**Re: Panda Express at 2040 Gibson Blvd SE (Lot C-2 Lovelace Heights Addition.)  
Erosion and Sediment Control Plan  
Engineer's Stamp date 11/19/2024 (M15E021F) SWQ-2025-00012**

Based on the information in your submittal received on 2/21/25, the above-referenced ESC Plan can't be approved until the following comments are addressed.

FILTREXX® SEDIMENT CONTROL

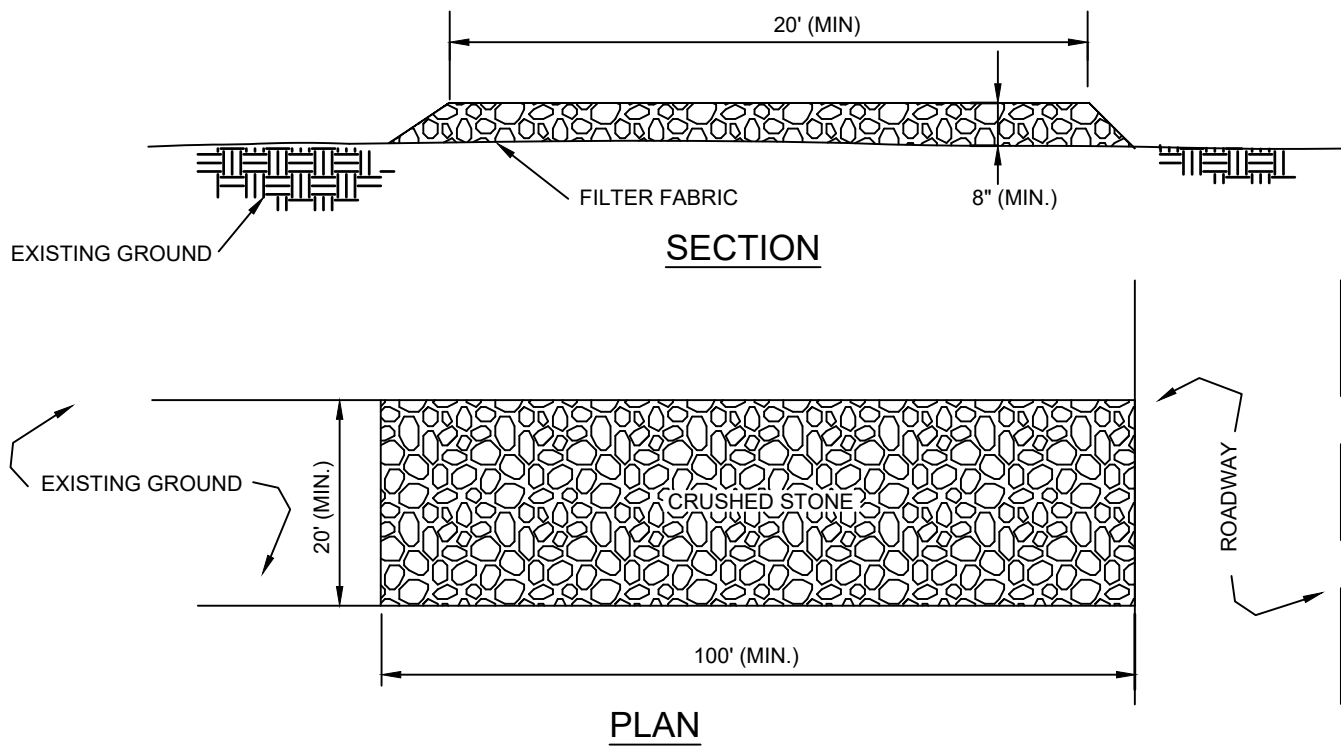
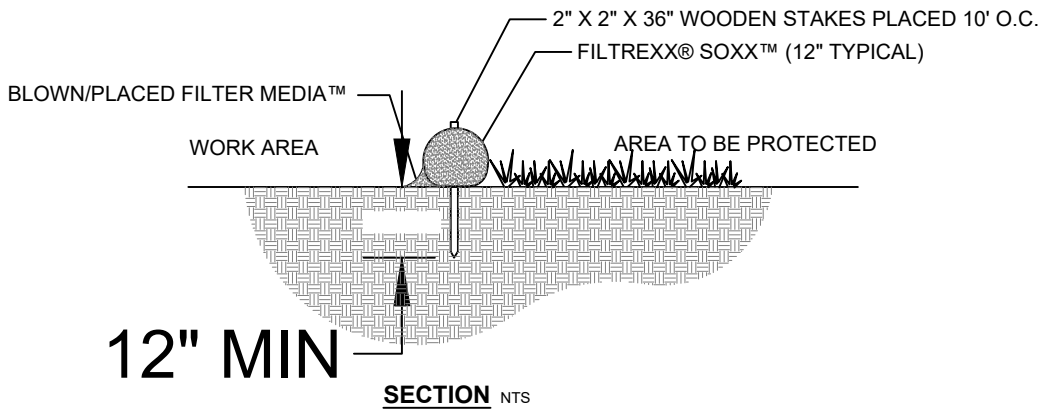
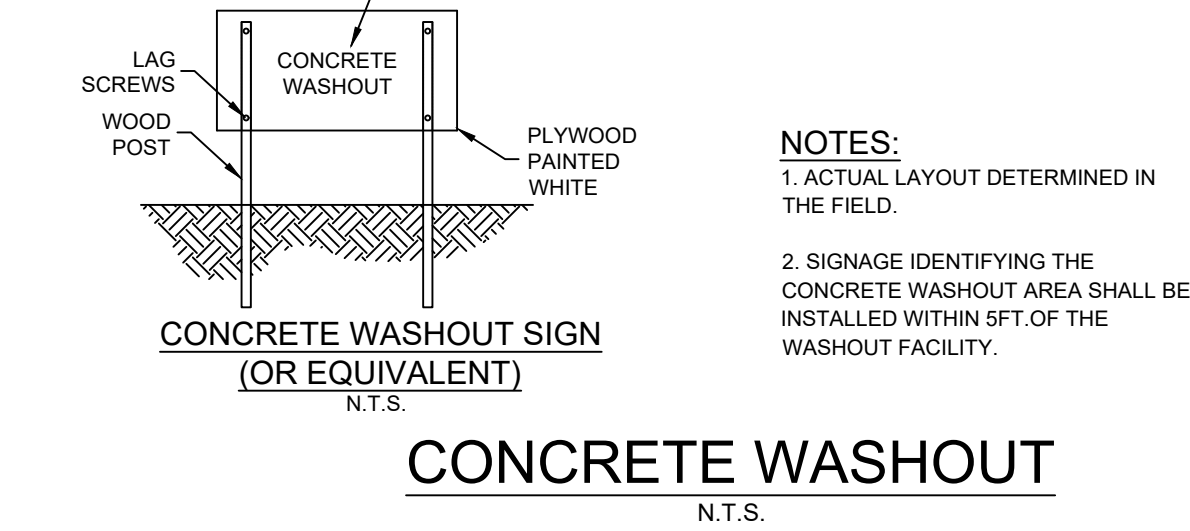
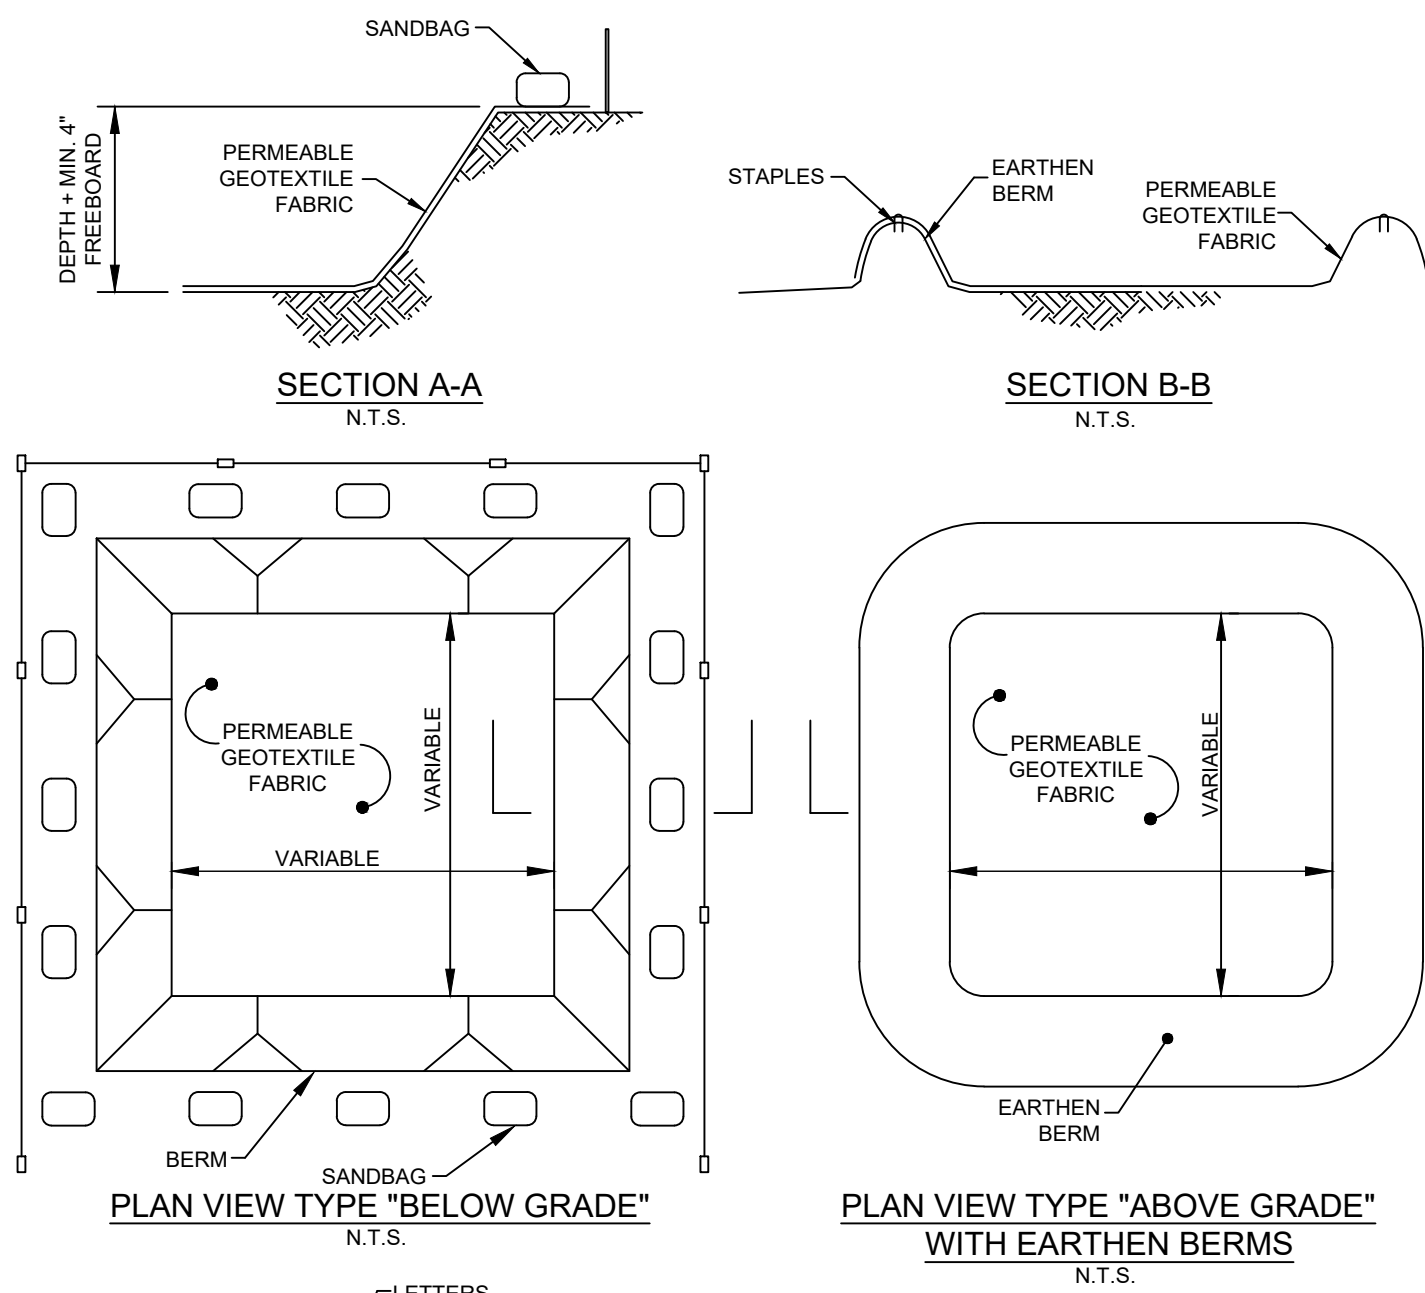
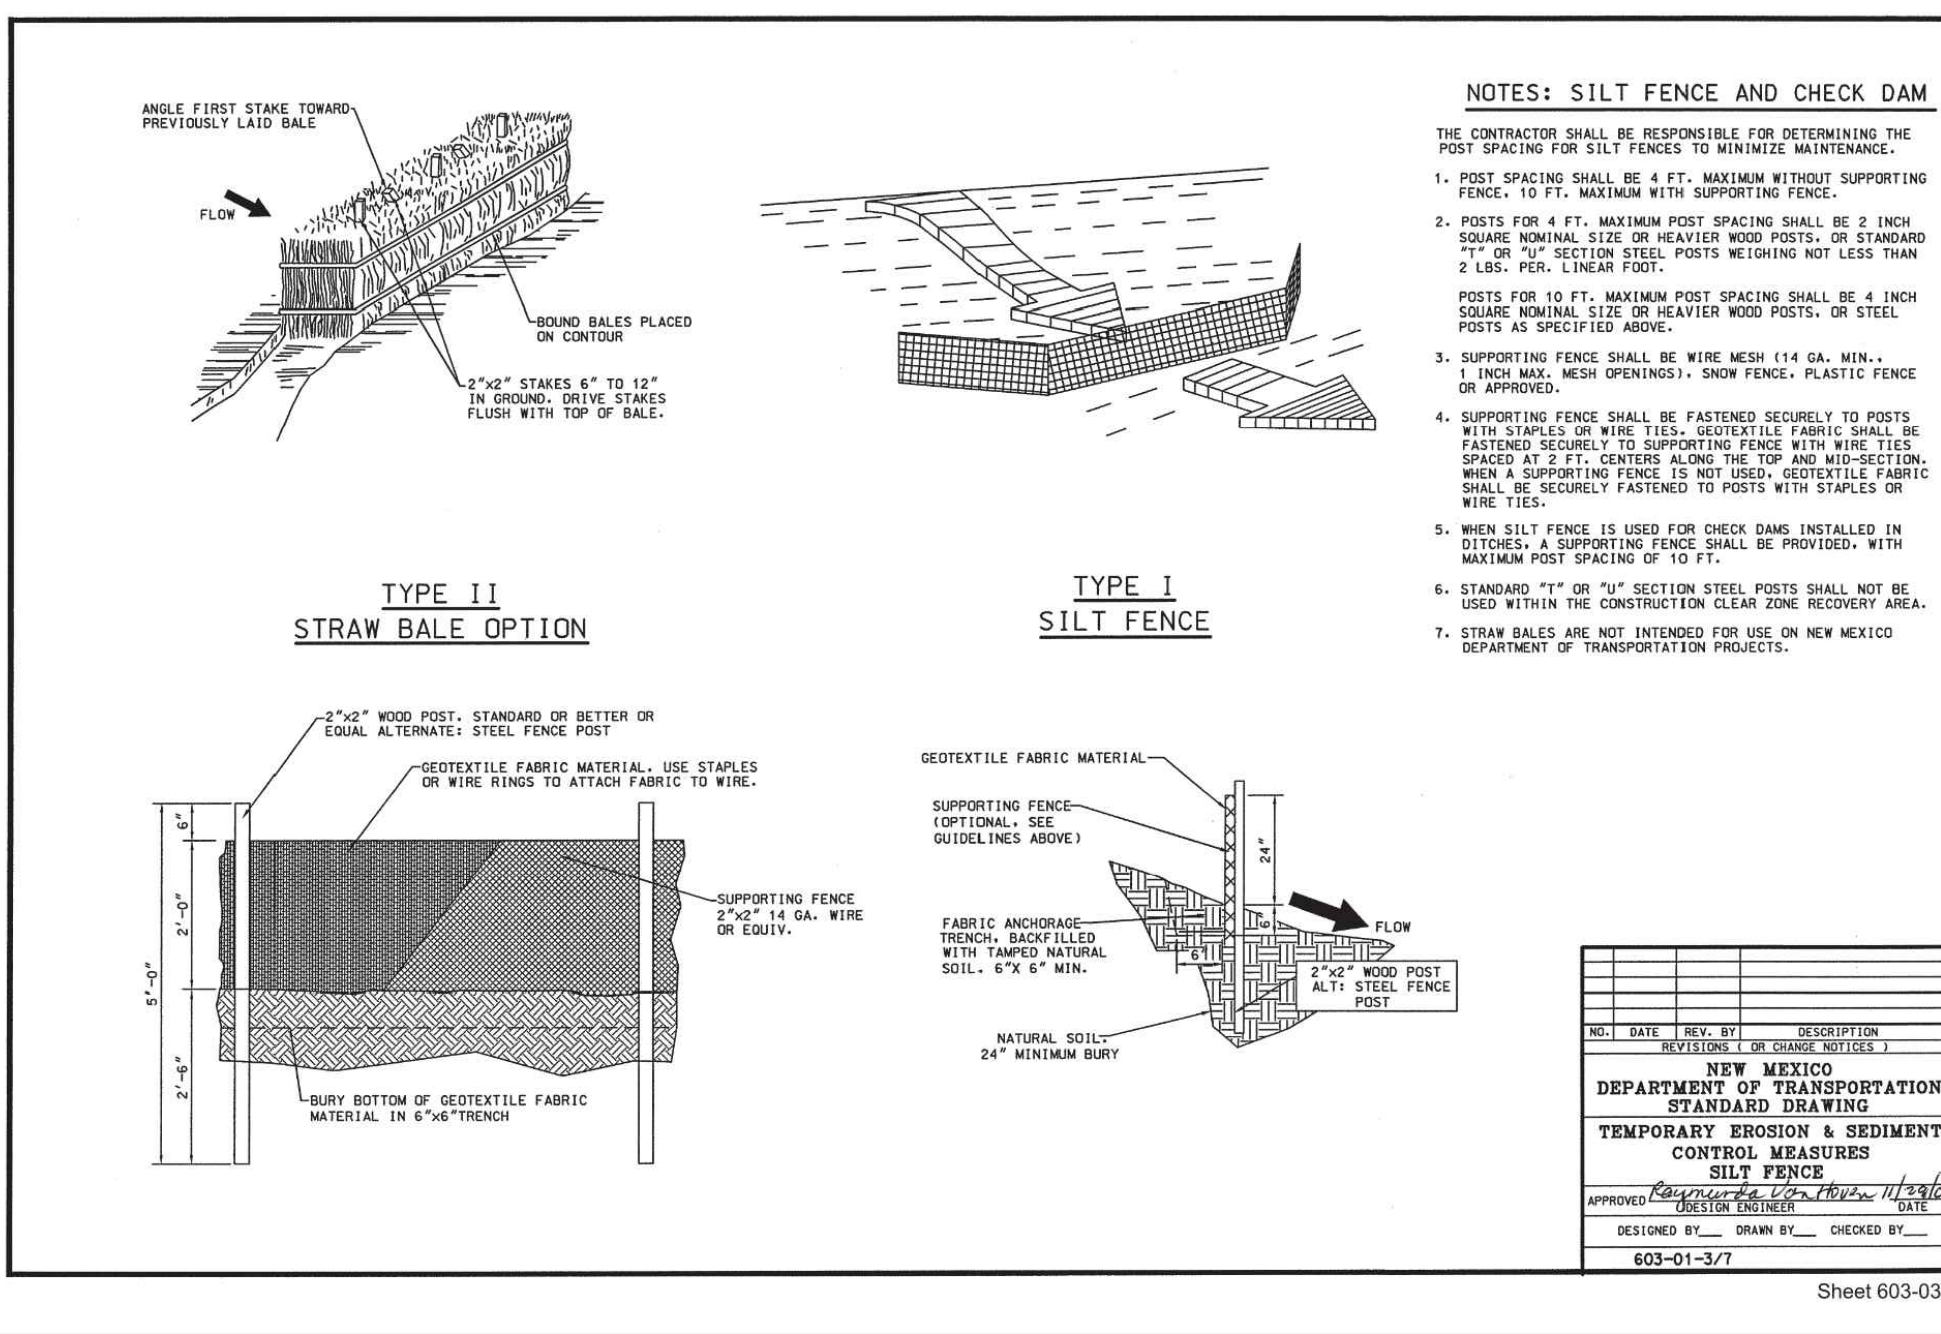
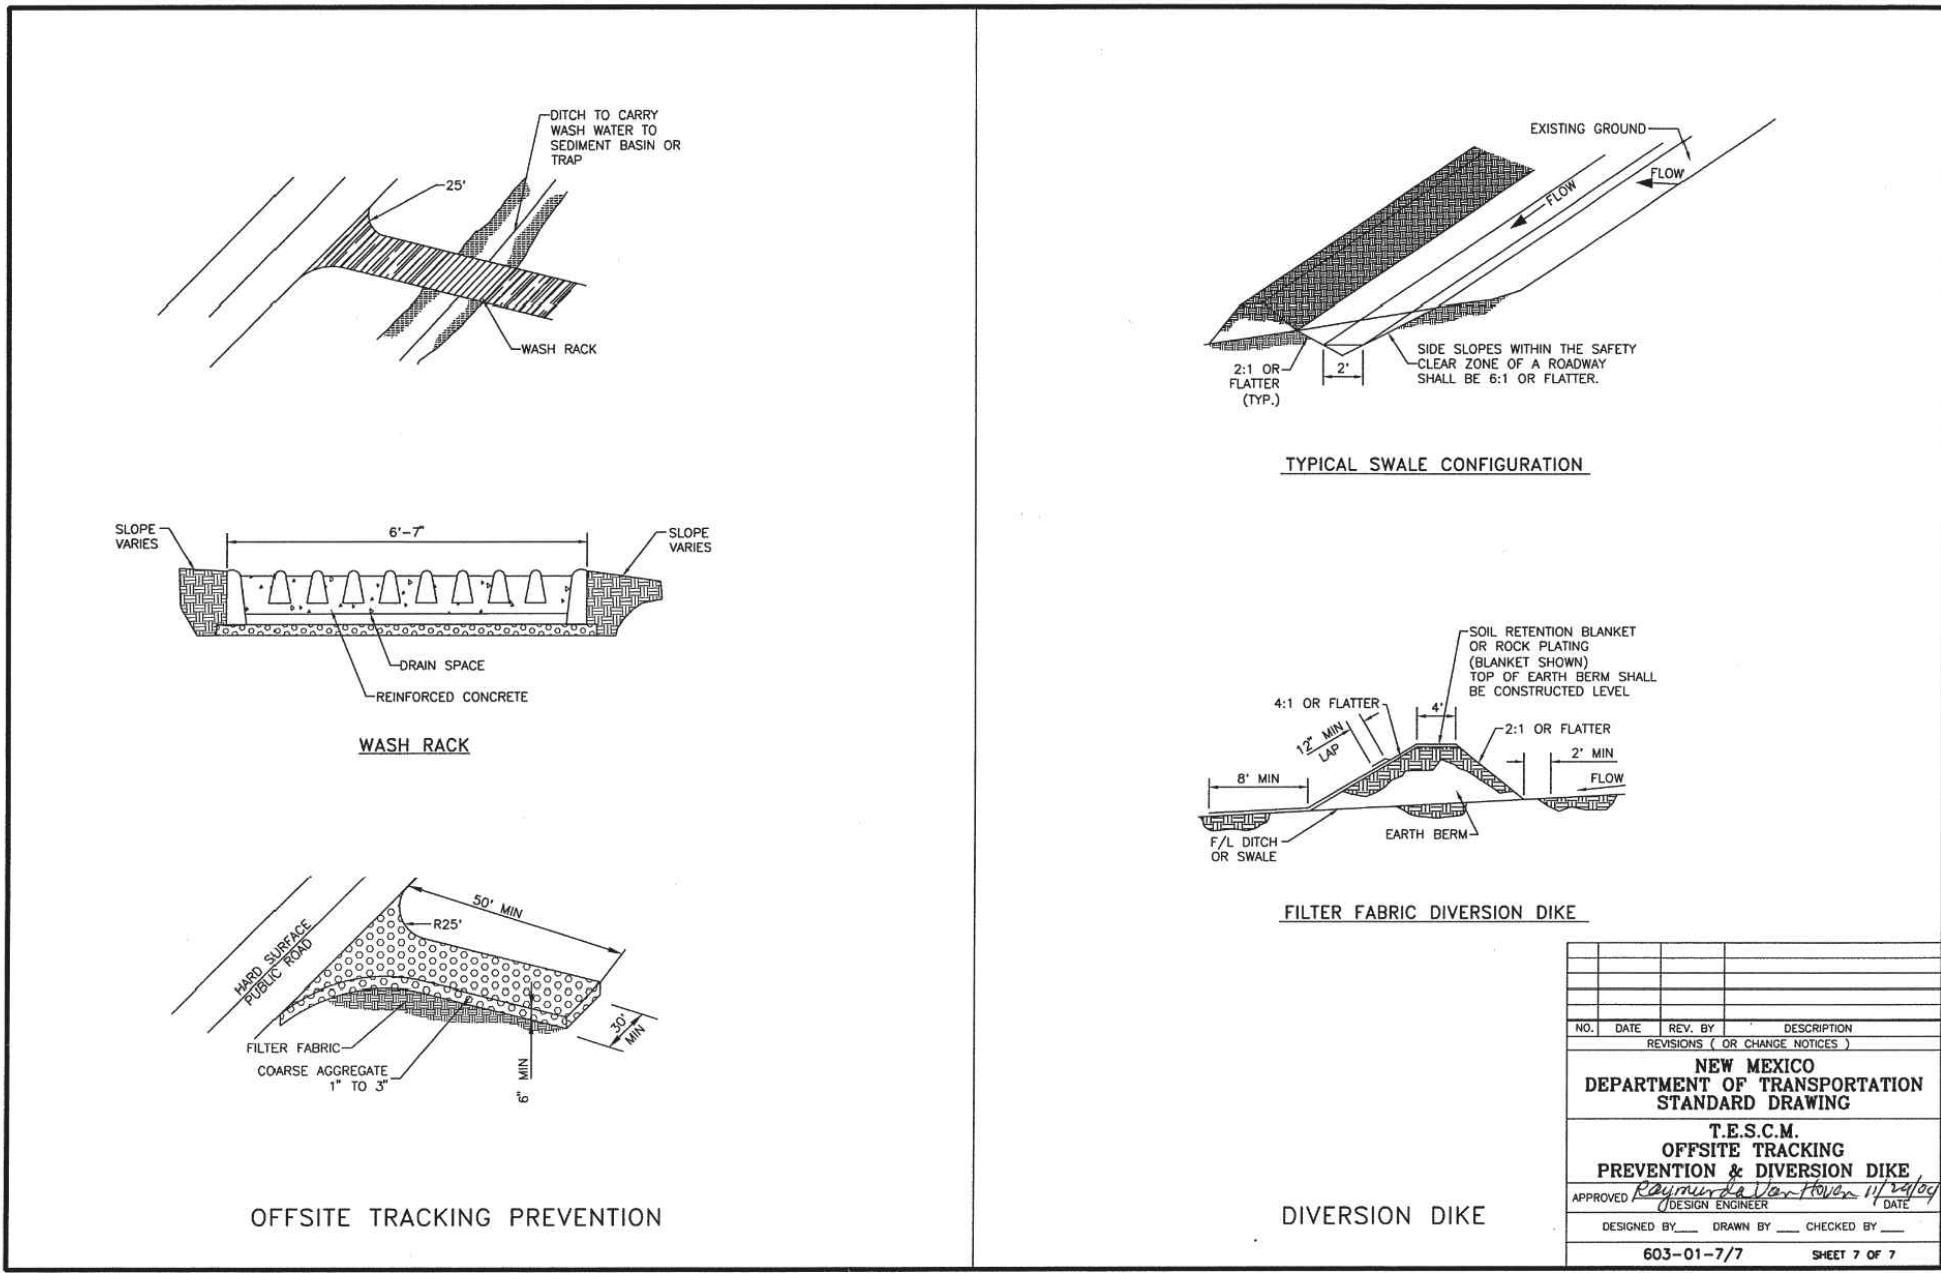
7. Construction details and specifications are missing from the ESC Plan for most of the stormwater controls, including but not limited to Stockpile Management, Silt Fence, Diversion Berms, and Sediment Traps. NMDOT has details for most of these BMPs at [NMDOT NPDES Manual Rev 4 2023](#) in Appendix A. Mulch socks don't seem appropriate, but if used, they should be staked per NMDOT detail instead of weighted down.
